Addendum No. 1

RE: Contract ID: C201144
WBS# 34934.3.3
Wake County (U-3344A)
SR-3015 (Airport Blvd.) From NC-54
to McCrimmon Parkway at Morrisville

January 16, 2007 Letting

08-JAN-2007 11:59 \\dot\dfs\o\070\proj\top\projects-u\3344a\traffic\tr\officecontrol\top\3344a.tc_top08.dgn AT WZTC22101 sisykes

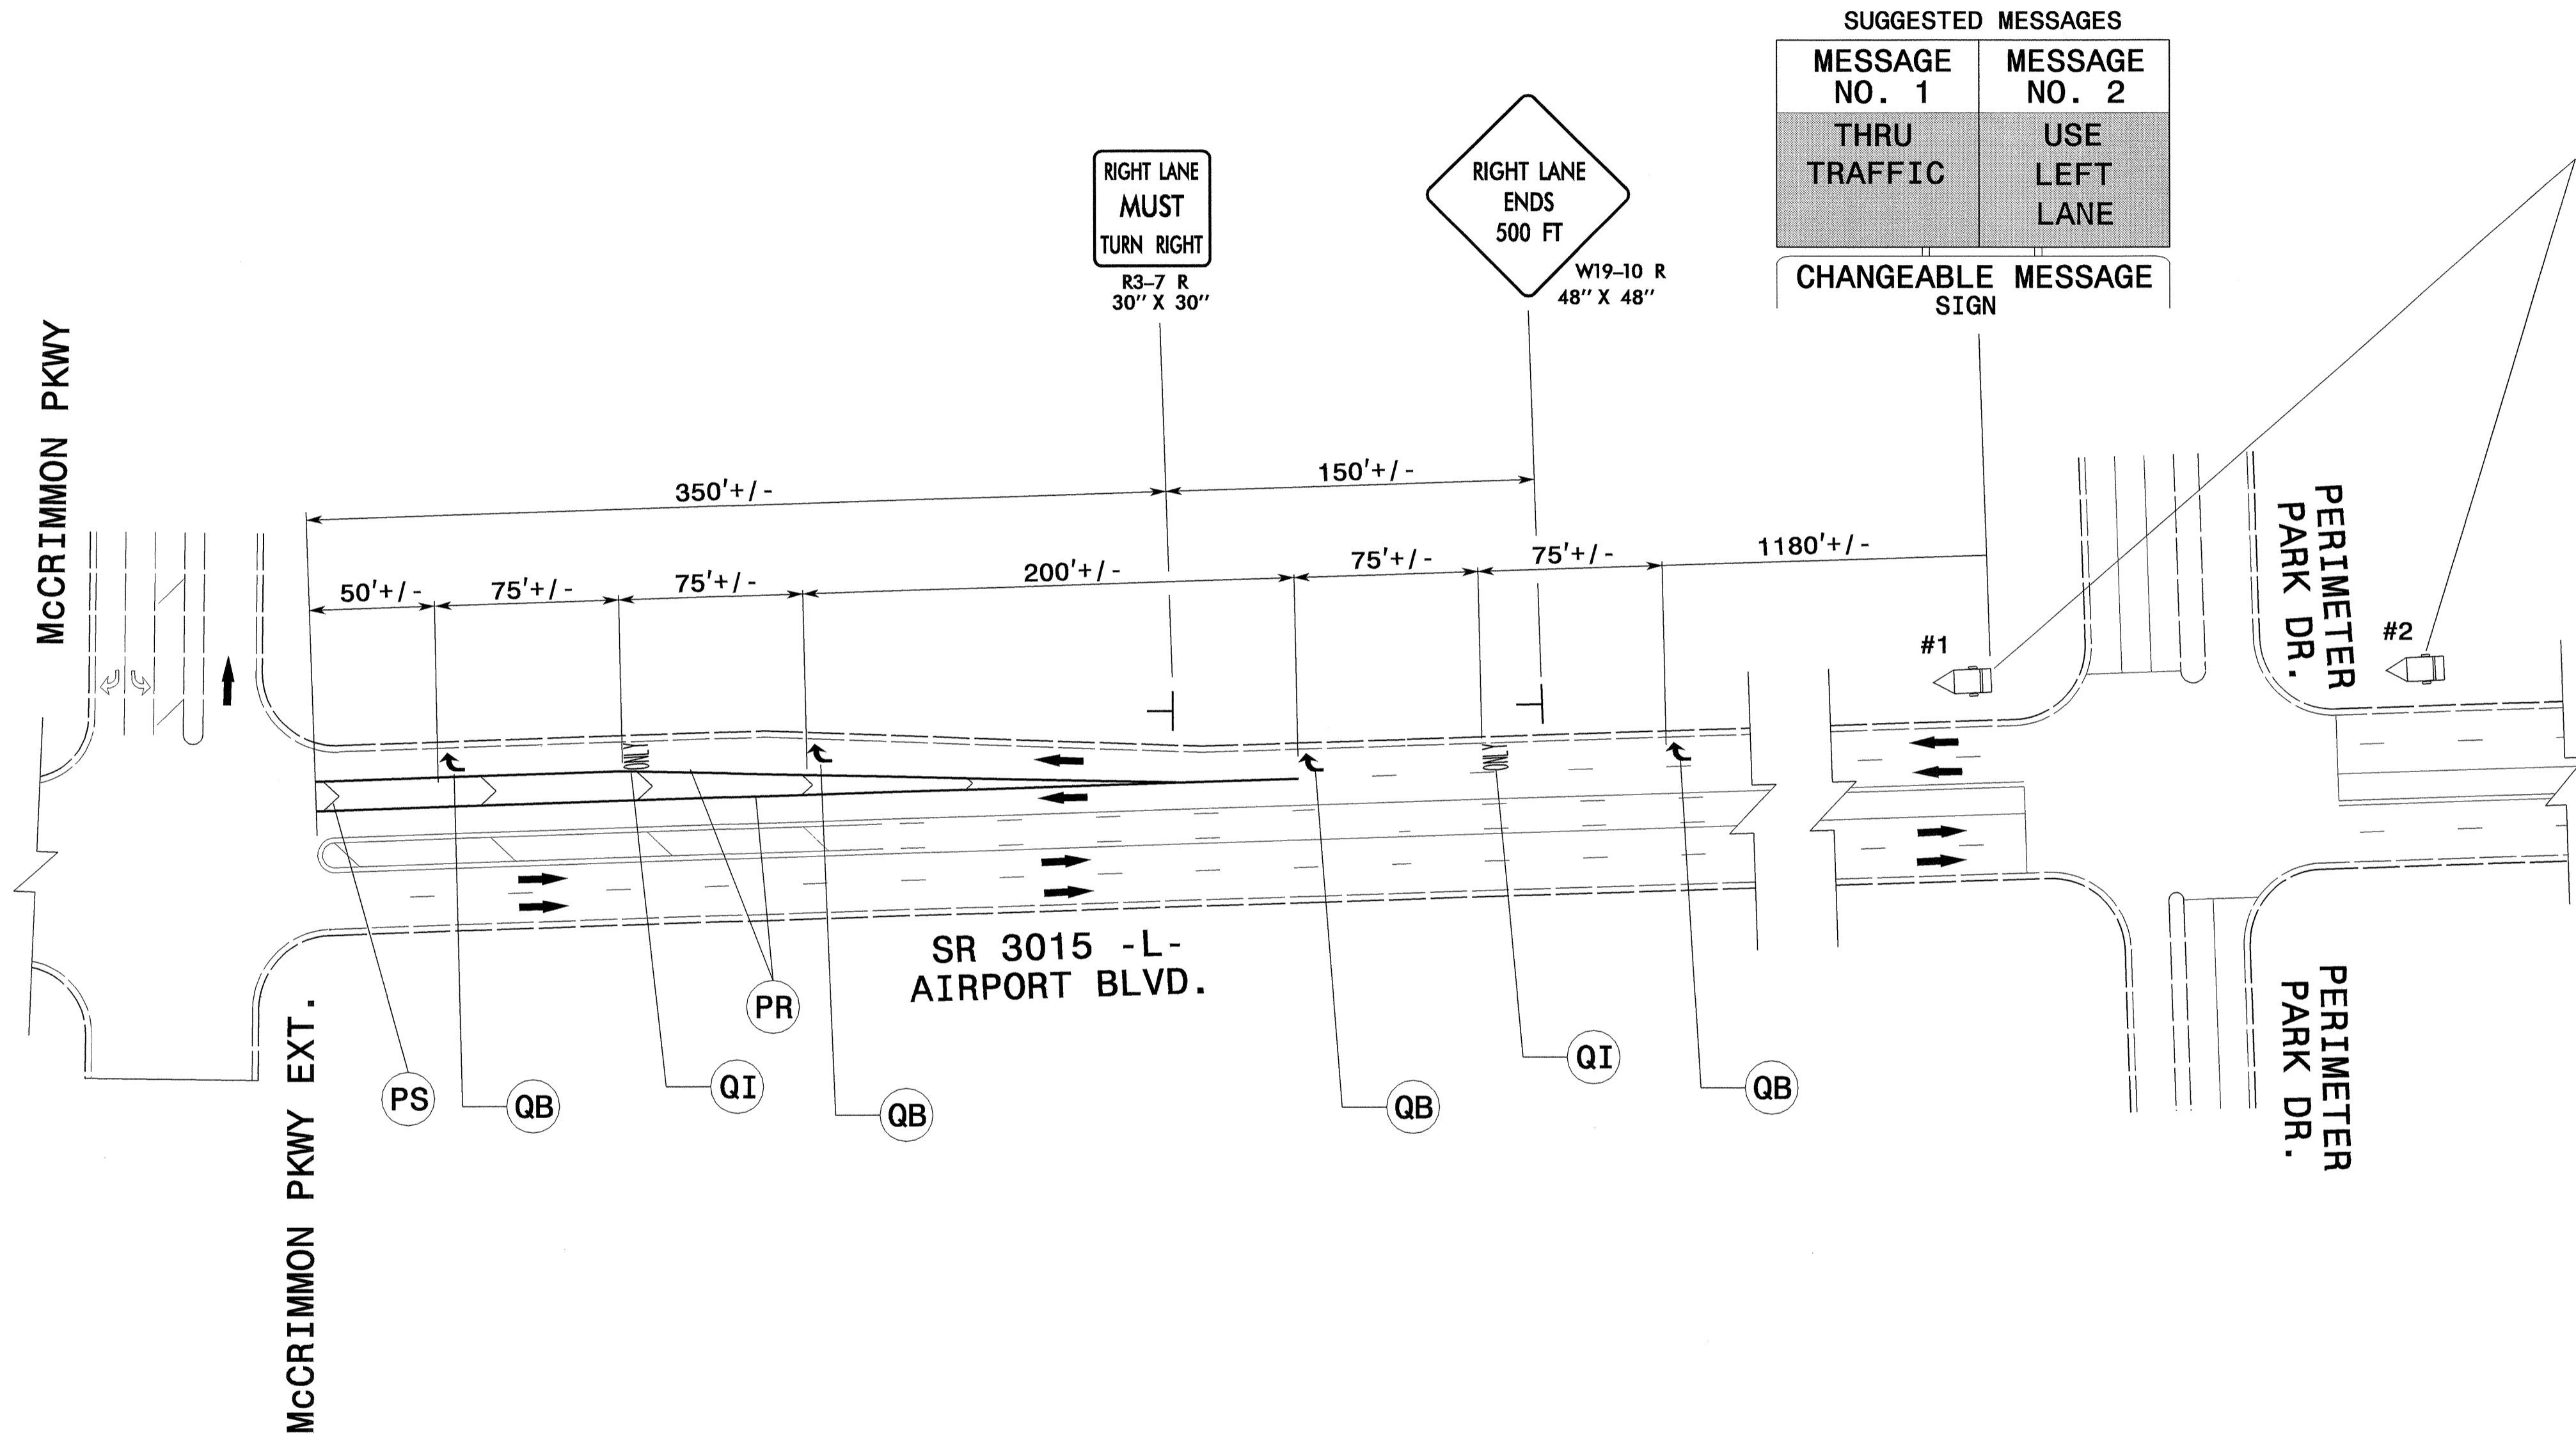
On Sheet TCP-8, the notes have been revised to eliminate the note indicating to "see subsurface plans". Please void Sheet TCP-8 in your plans and staple the revised Sheet TCP-8 thereto.
